From: Judith Ward
Sent: 10 December 2020 15:19
To: Linda Griffiths
Subject: 20/01162/DISC OS Parcel 7400 adj and south of Saltway

Judith Ward
Landscape Planning Officer
Cherwell District & South Northants Councils

TITLE
CUT AND FILL ANALYSIS
SOUTHERN GATEWAY
LANDSCAPE MOUND SECTIONS

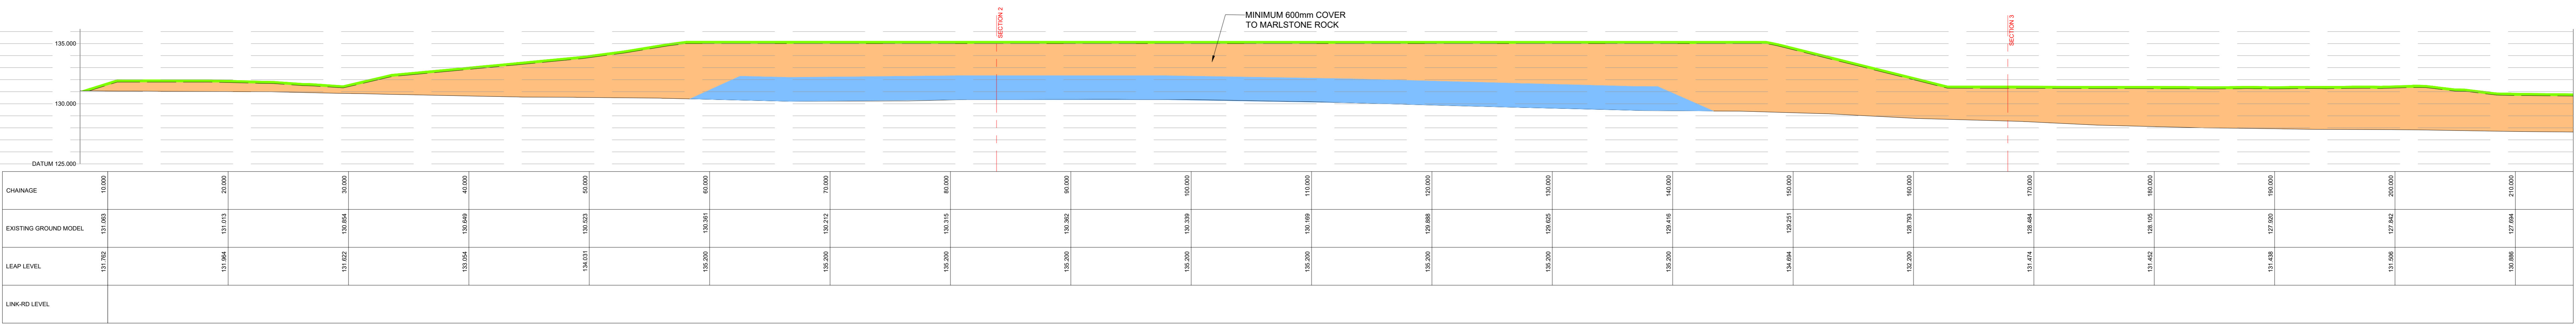
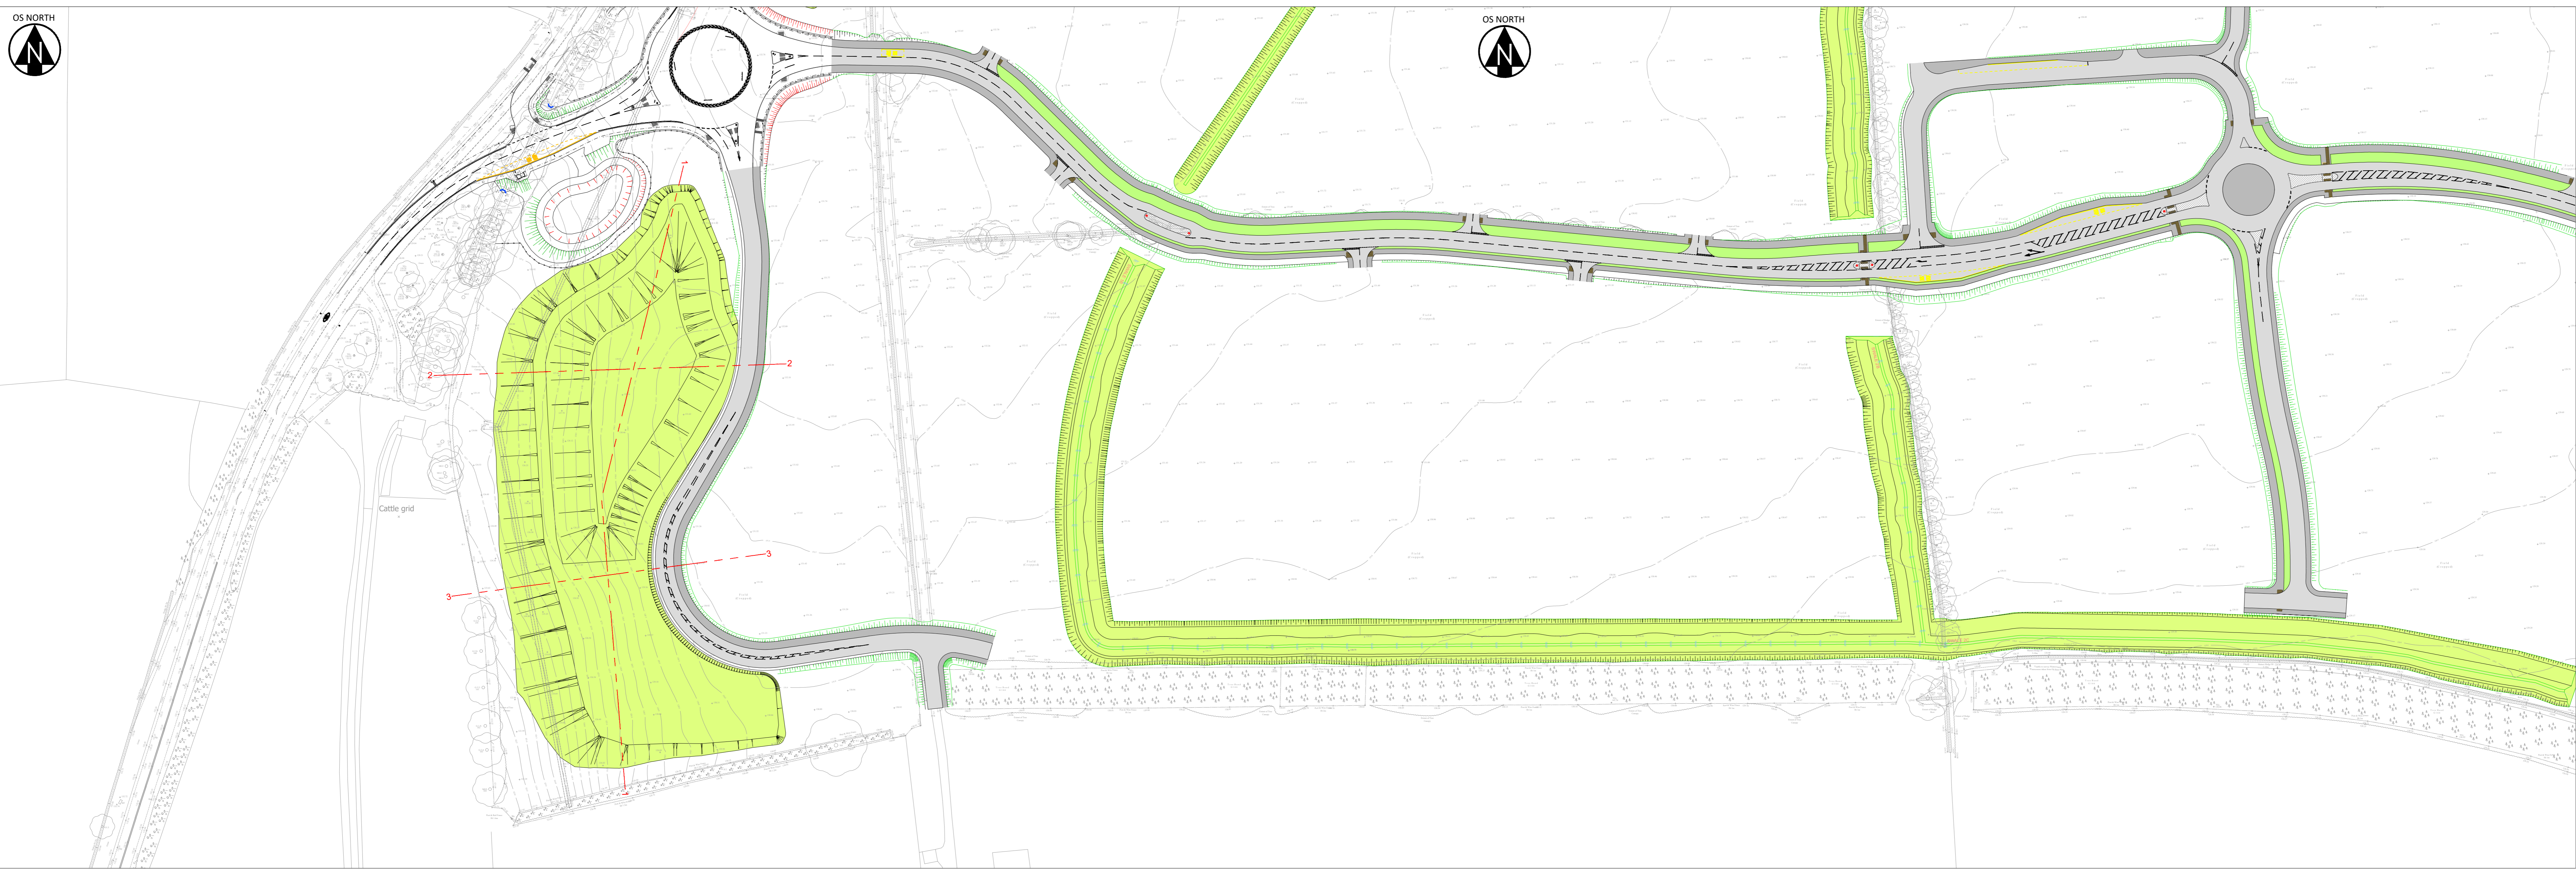
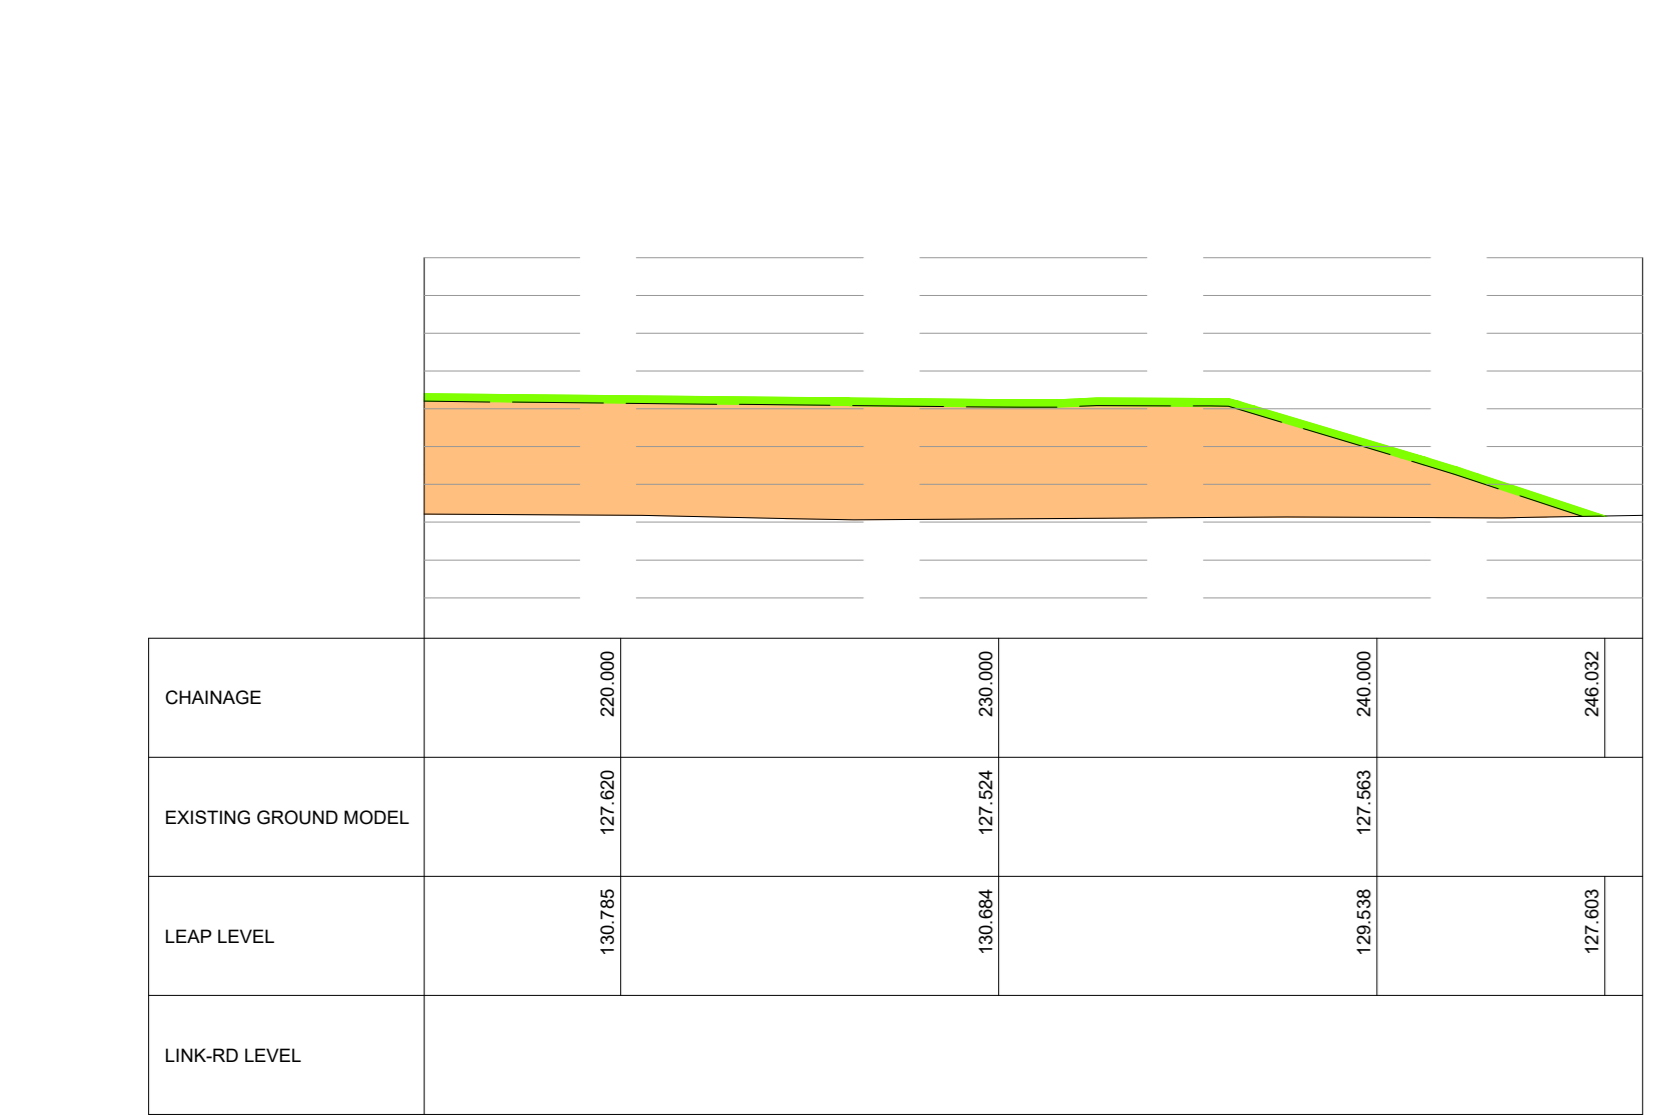
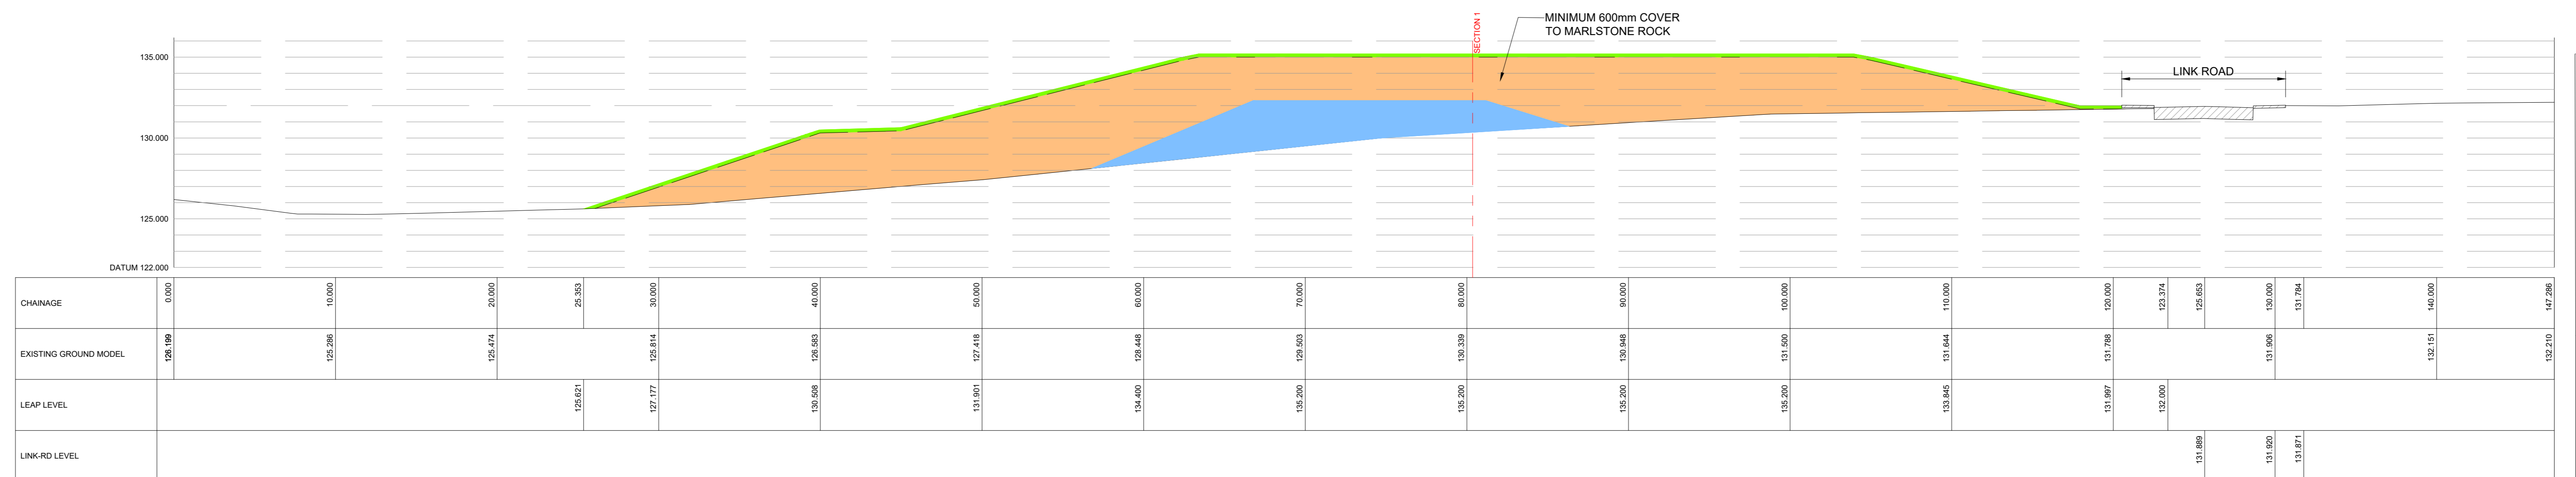
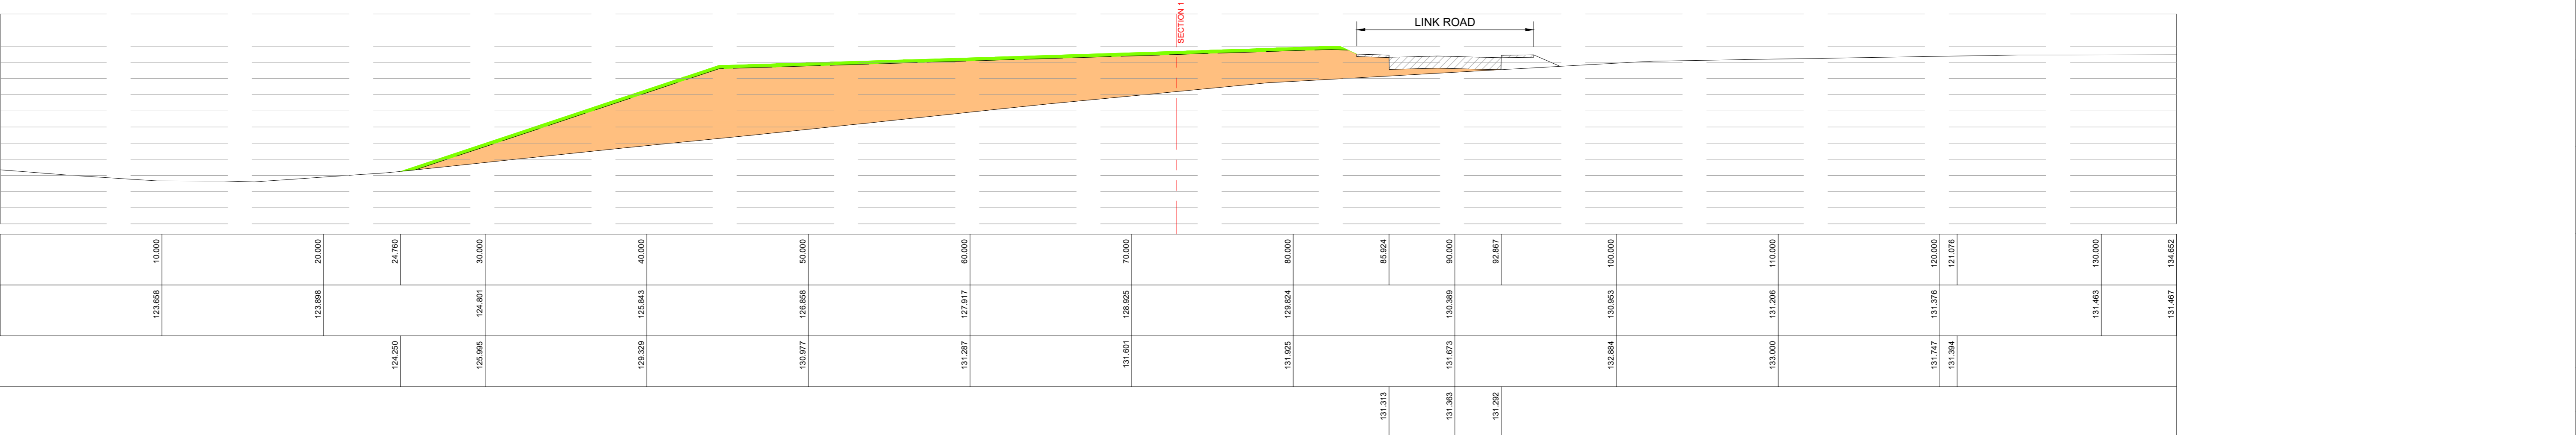
I have concerns about how the grading of the Gateway landscape mountain fits in with providing a play facility on the top. It is 9m high in places and there will be a requirement to have vehicular access to maintain a play area which hasn't been designed yet
